Our ref: RA/2023/146640/04-L01
Your ref: 2023/93539

OUTLINE APPLICATION, INCLUDING THE CONSIDERATIONS OF ACCESS APPEARANCE, LAYOUT, AND SCALE, FOR THE ERECTION OF A SIX-STOREY BUILDING TO HOST 76 RESIDENTIAL APARTMENTS (C3 USE) AND ANCILLARY WORKS COMPRISING DEMOLITION OF VACANT BUILDING, FORMATION OF NEW ACCESS, PARKING AREAS, OPEN SPACE AND LANDSCAPING; ERECTION OF CYCLE AND BIN REFUSE STORAGE STRUCTURES – LAND ADJ, LEDGARD BRIDGE MILL, BACK STATION ROAD, MIRFIELD, WF14 8NZ

- Technical Note - JBA Project Code 2024s0643, Ledgard Mill, 27 June 2024 - Building on void - Technical parameters

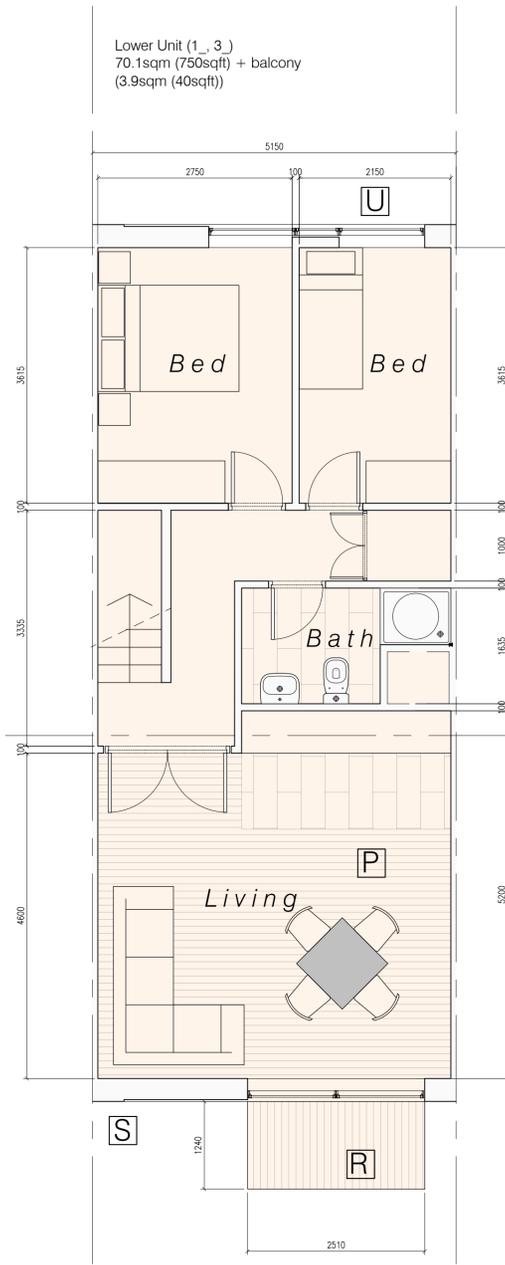
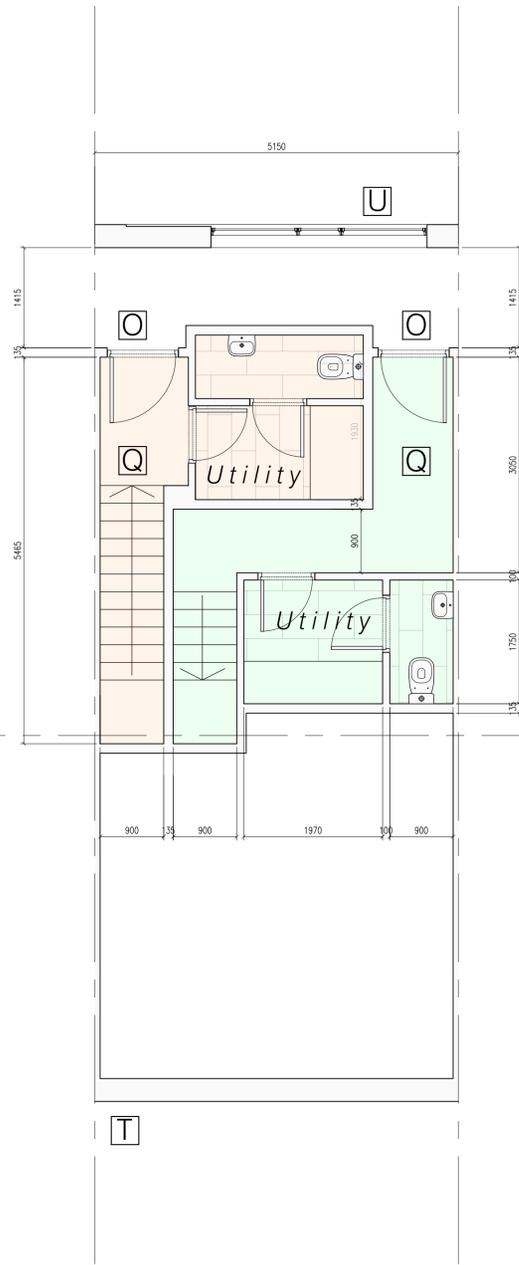
There will be vertical bars – 10mm diameter with 100mm spacing. This stops people getting in but also is bad for debris collection. Because of this, maintenance of the void entrances is critical.

Figure 1 shows a sketch of the proposed void solution. It says that it is recommended that Architectural Drawings on planning portal should be updated to reflect these design parameters. This will need to be done in order for us to be able to recommend
